**WELWYN HATFIELD COUNCIL – DEVELOPMENT CONTROL**  
**DELEGATED REPORT**

<b>APPLICATION No:</b>	<b>S6/2009/2749/FP</b>
------------------------	------------------------

The application seeks full planning permission for the 'erection of a two storey residential extension, first floor granny annexe and B1 (office) replacement following demolition of existing ground floor offices.'

PROPOSED PLANS AND ELEVATIONS

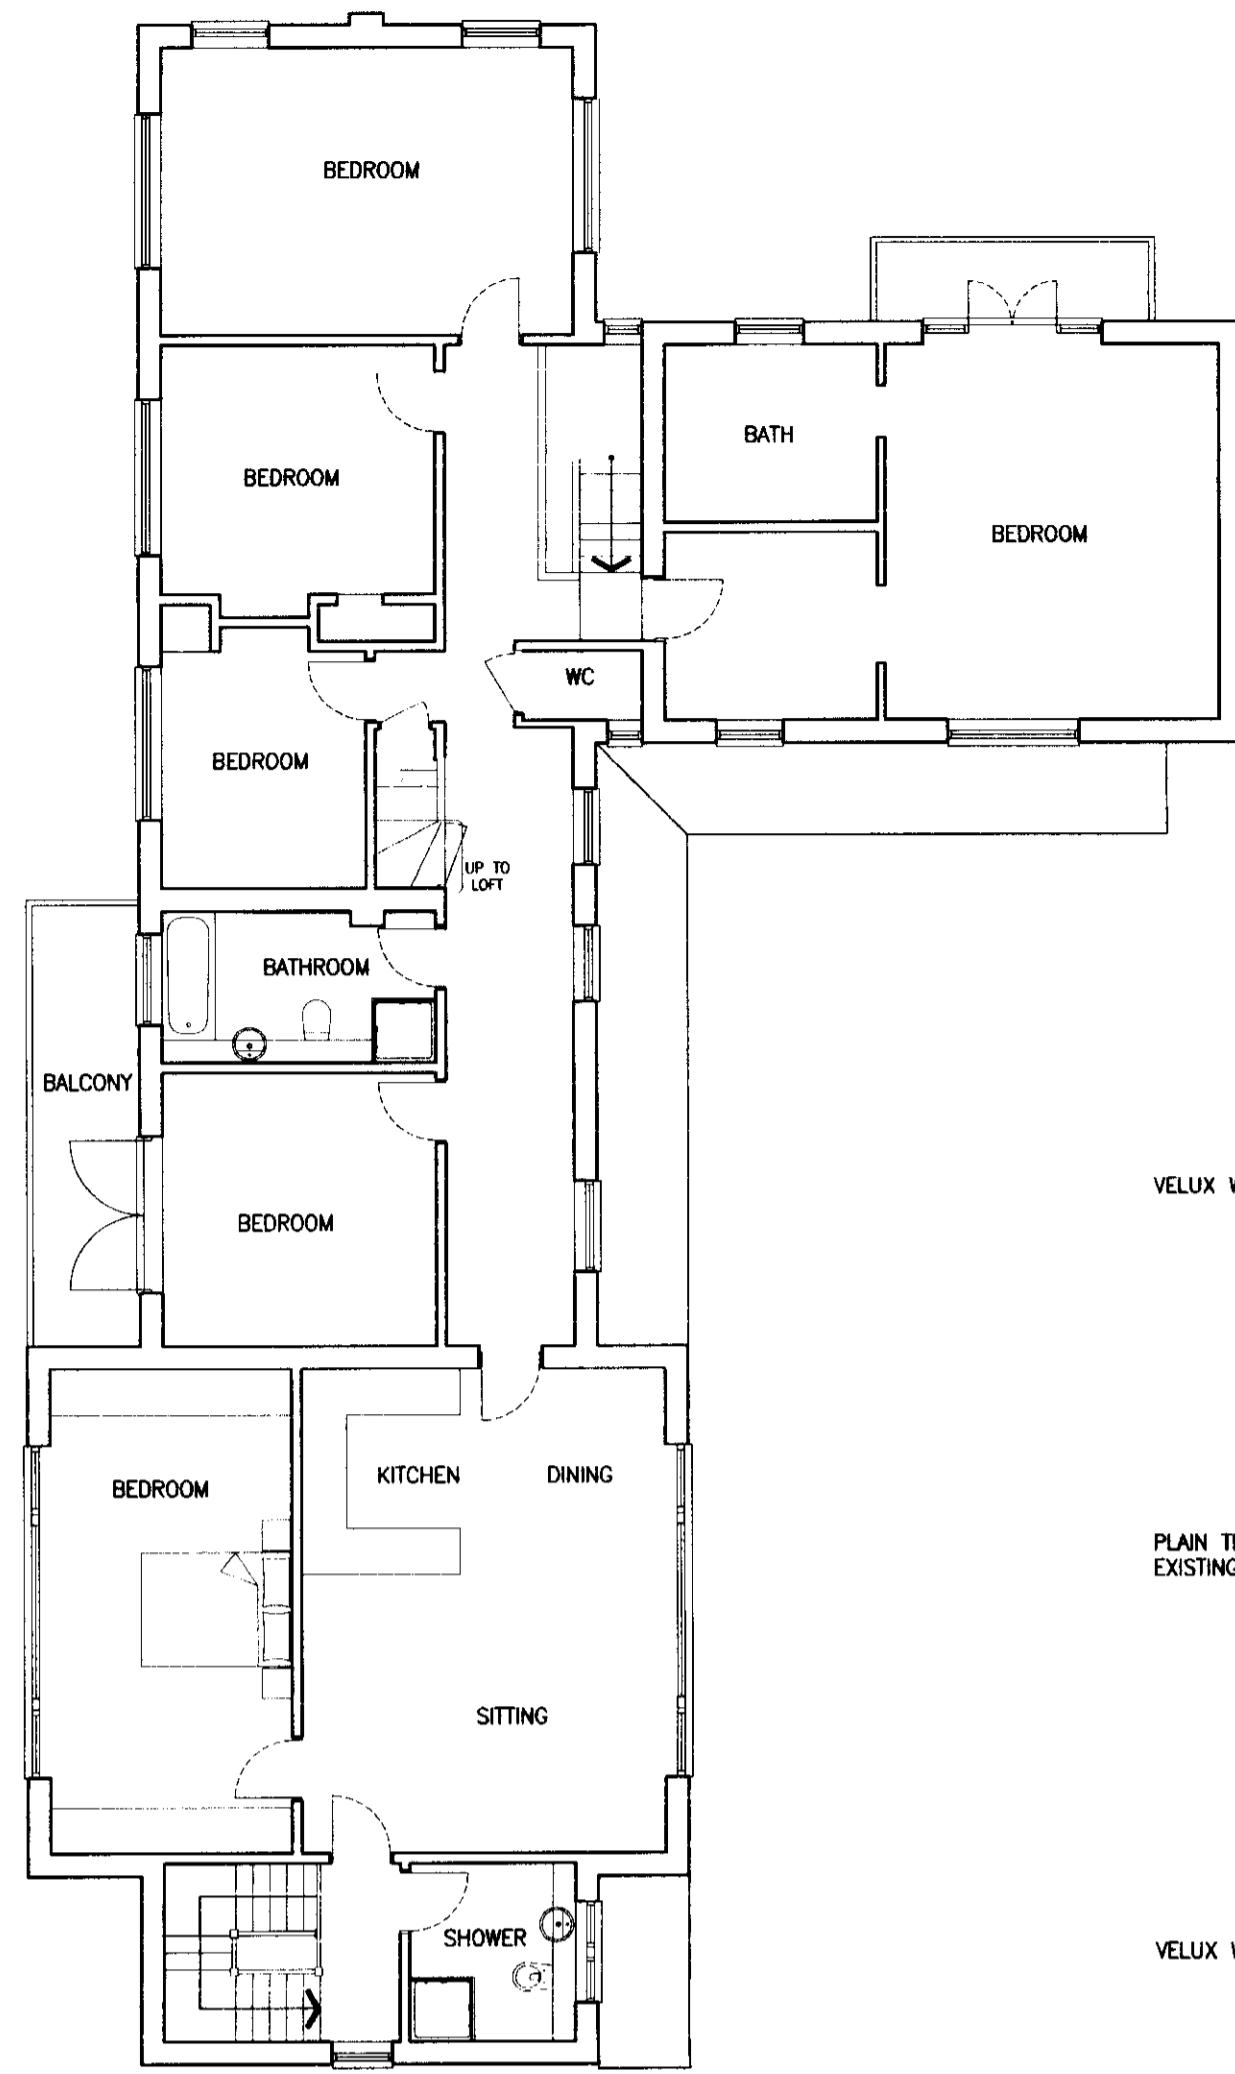
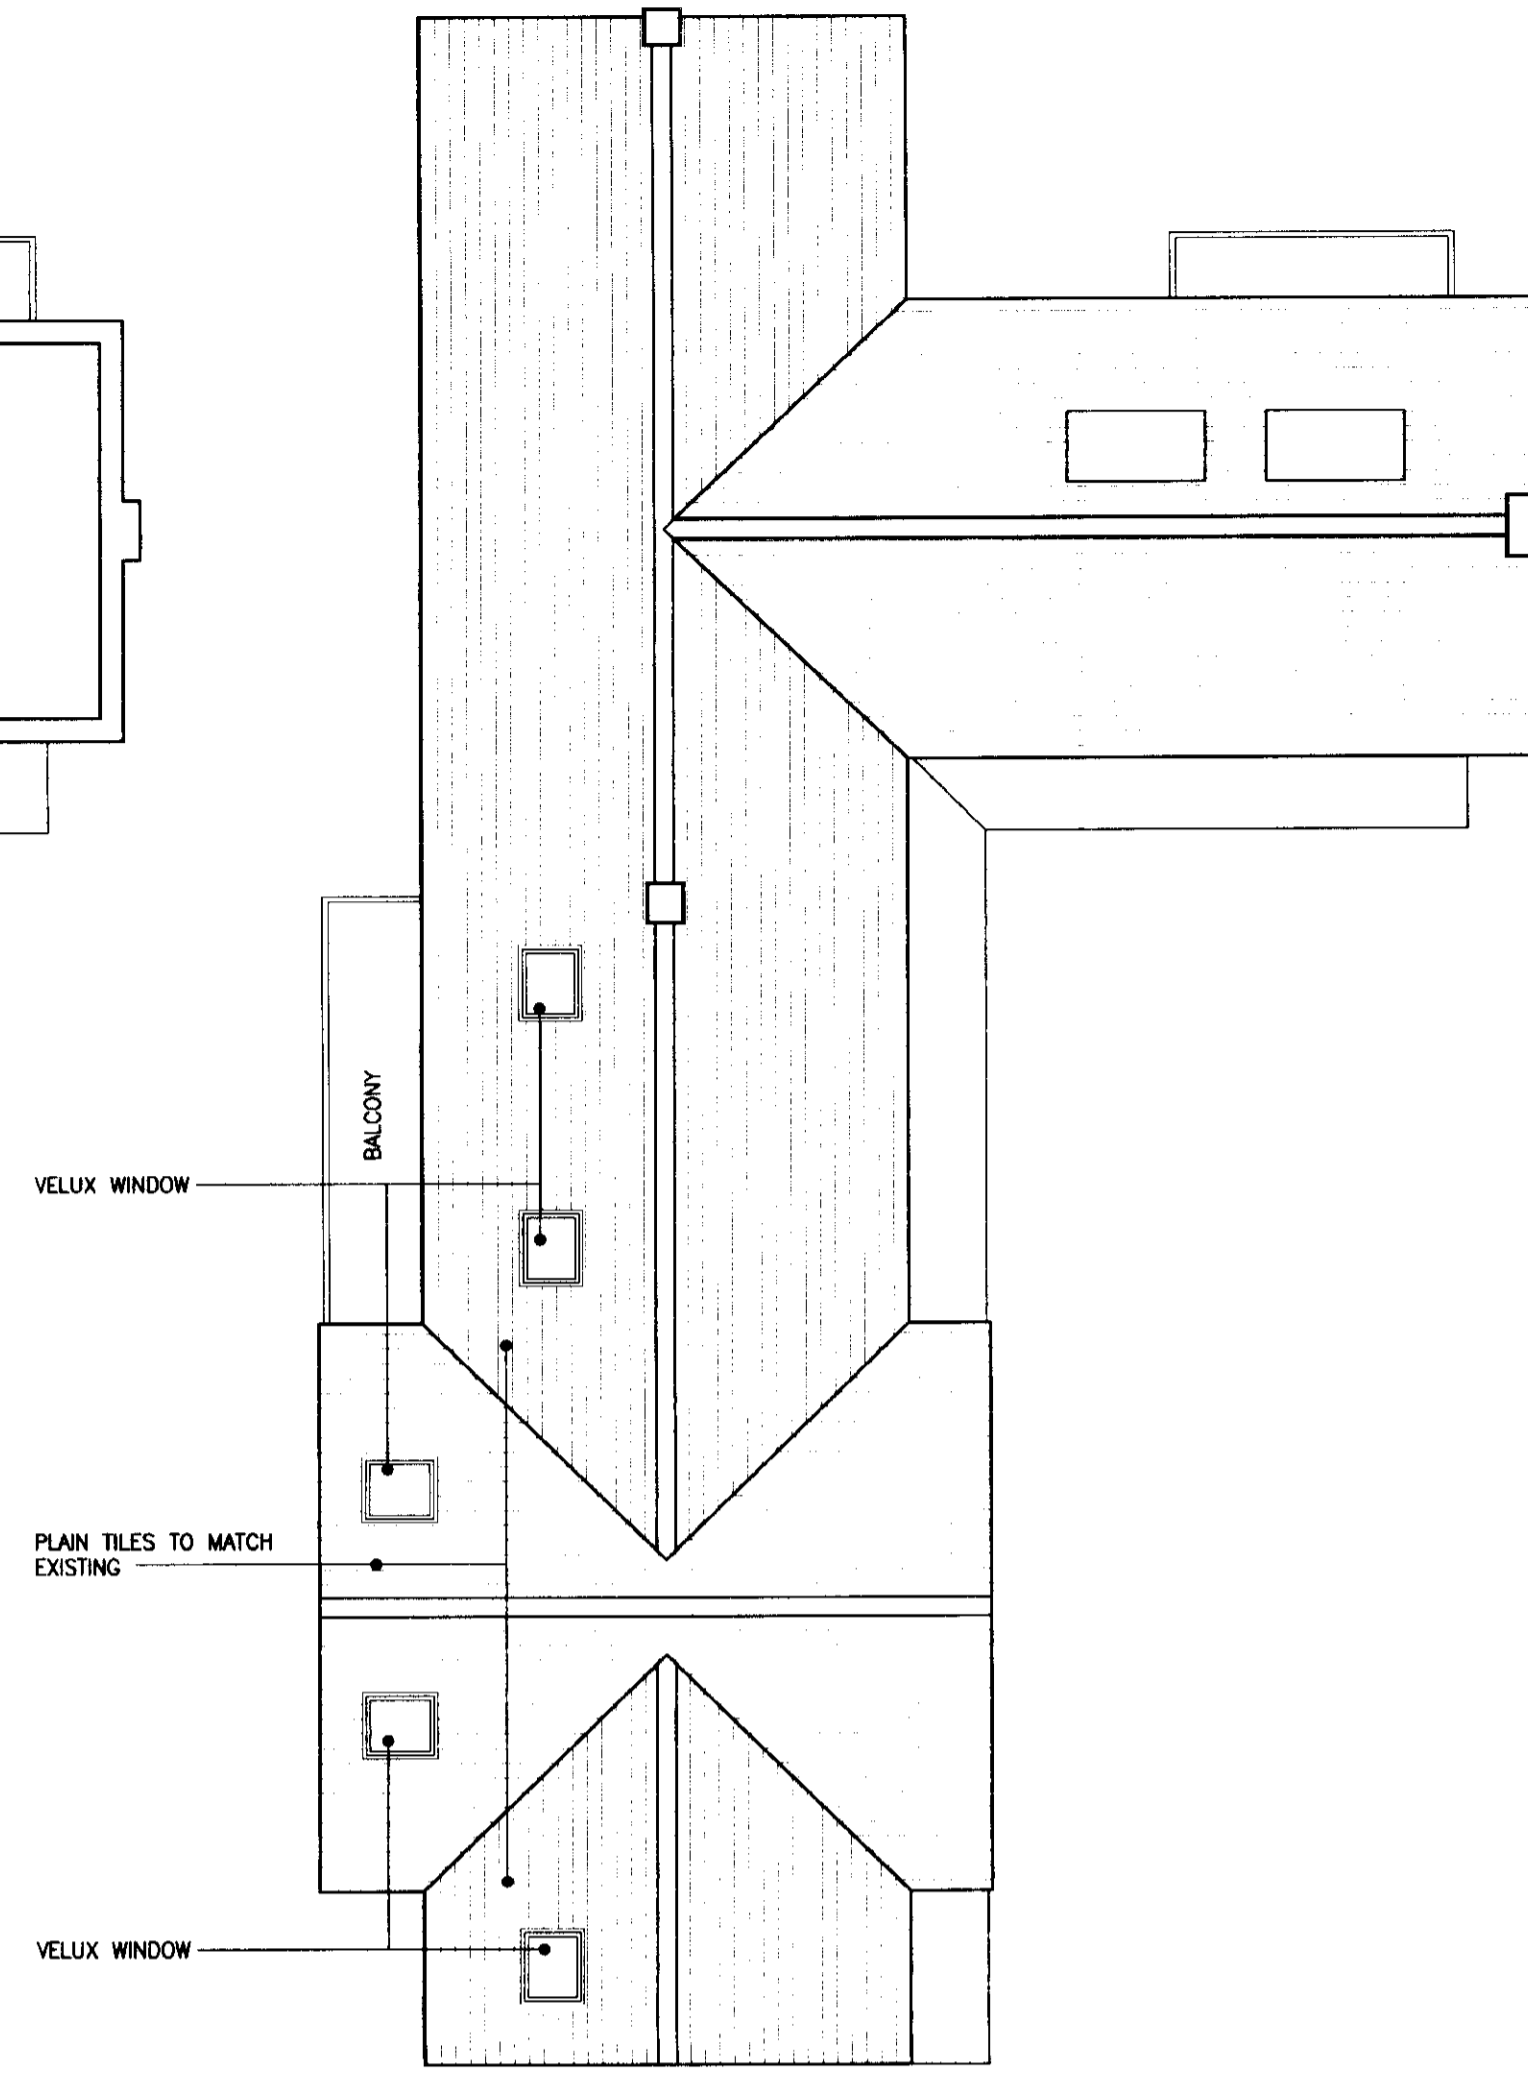
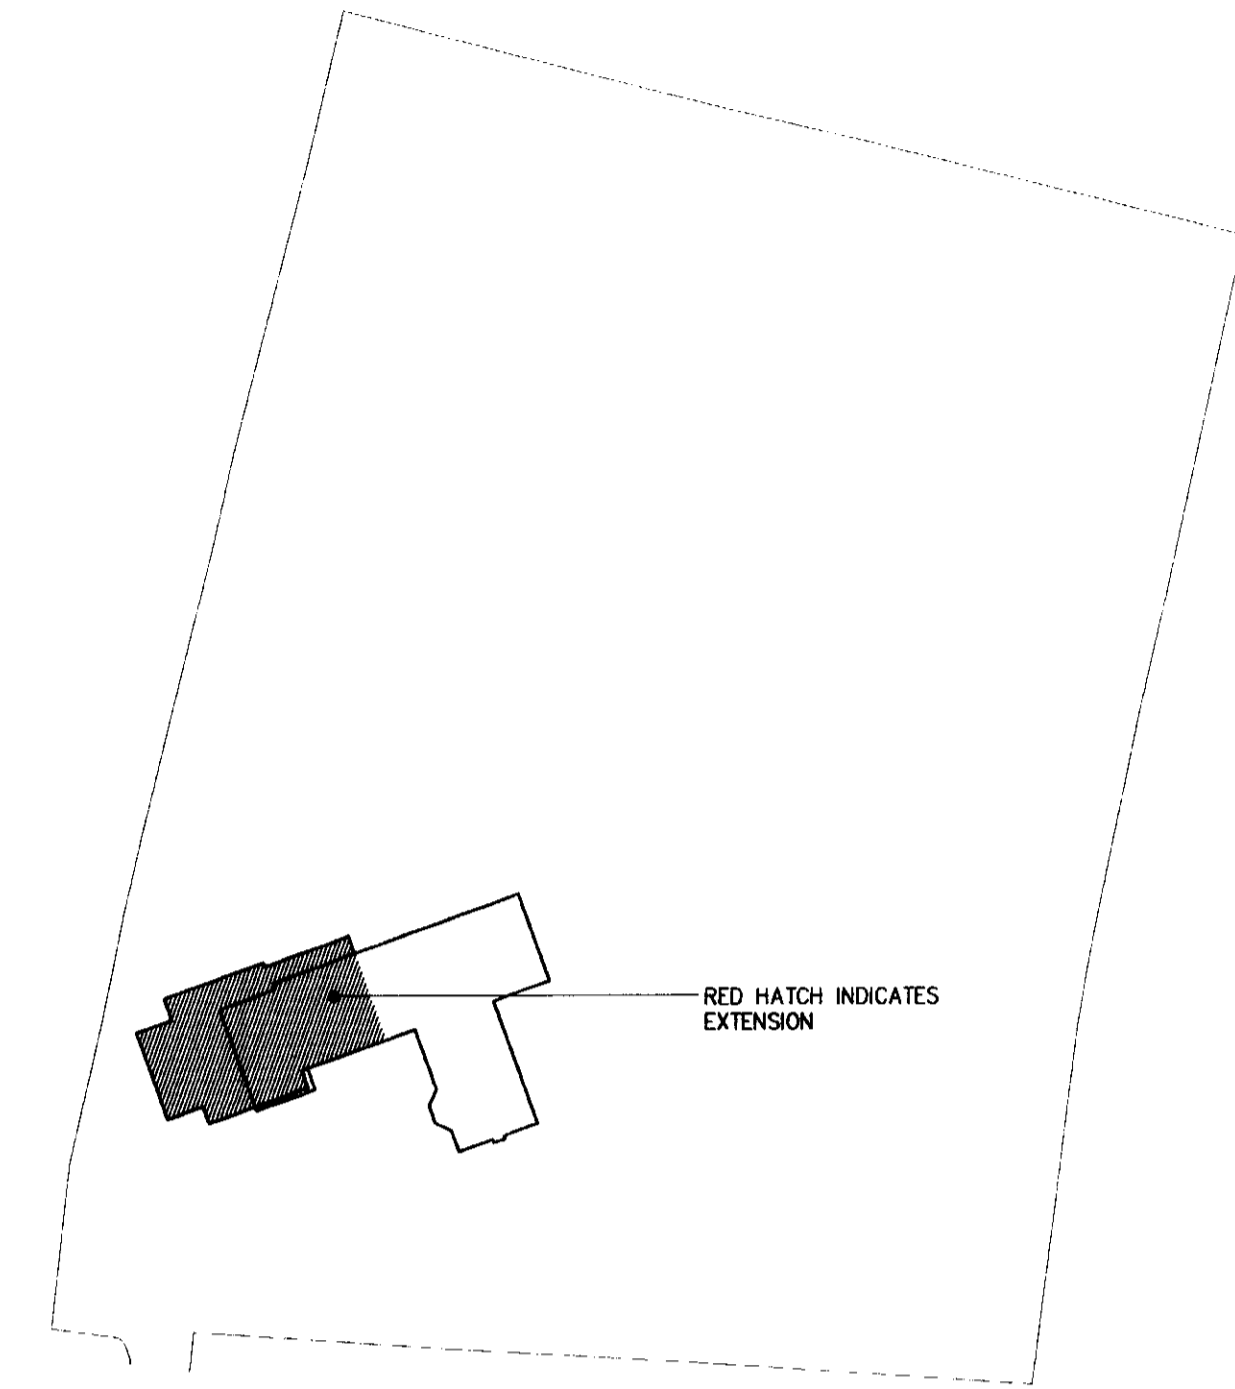
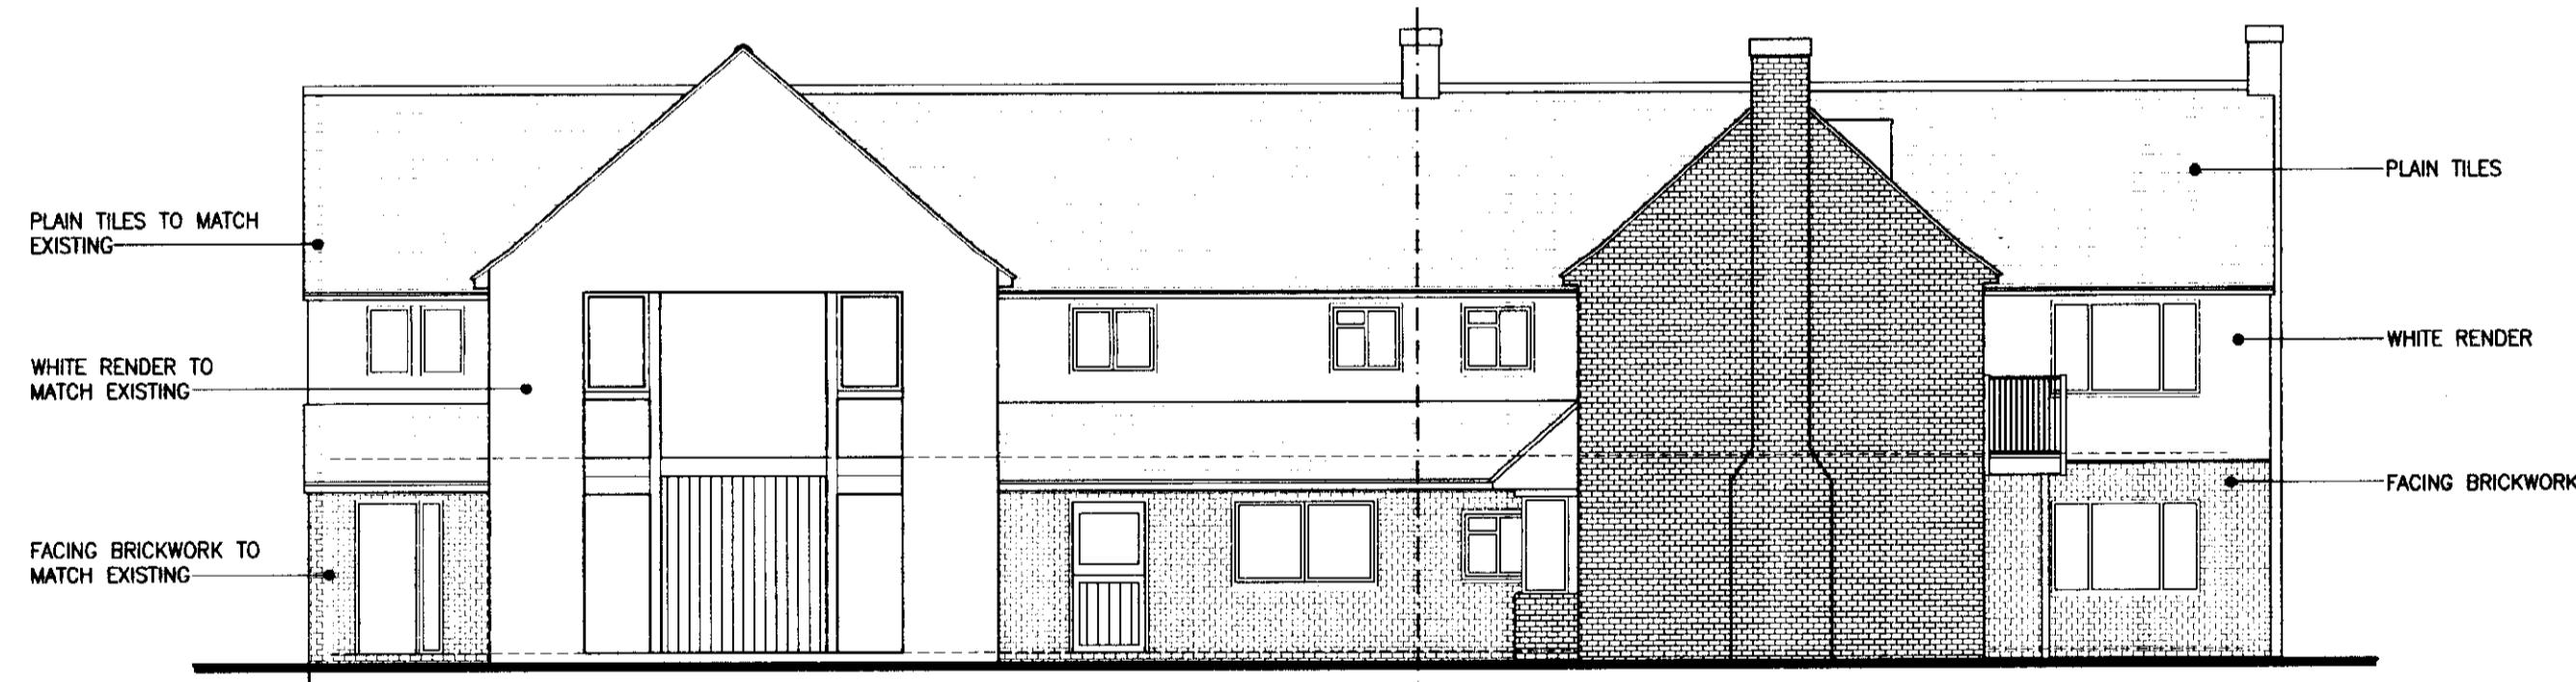
The proposed new resultant floor areas comprises approximately 174 sqm at ground level and approximately 228 sqm at first floor level giving an overall resultant floor area of approximately 402 sqm. This would result in an overall increase in new habitable residential floor areas since the 'original dwelling was built of 250 sqm which is approximately 164 % increase of floor area compared to the 'original' dwelling.

would not increase the height of the 'original' dwelling, but would add significantly further to its overall mass. Although the east side of the dwelling would remain in its existing form, the resultant building would increase significantly to the west with the proposed two storey extensions. This increase in mass along with the increase in habitable floor areas of 164% would result in a disproportionate addition over and above the size of the 'original' dwelling. The proposal is therefore considered to represent inappropriate development in the Green Belt. The proposal would fail the requirements of Criteria (i) of Policy RA3 and also PPG2.

- 1. The cumulative effect of the proposed development would, when considered in relation to previous extensions to the dwellinghouse, result in disproportionate additions over and above the size of the original dwelling due to the increase in the resultant floor area, size, bulk and mass. This would significantly reduce the openness of this part of the Green Belt to the harm of the rural character of the area contrary to the requirements of Policy RA3 of the Welwyn Hatfield District Plan 2005 and Planning Policy Guidance Note 2 (Green Belt). There are no very special circumstances which have been advanced to justify a departure from the Green Belt Policies of restraint.
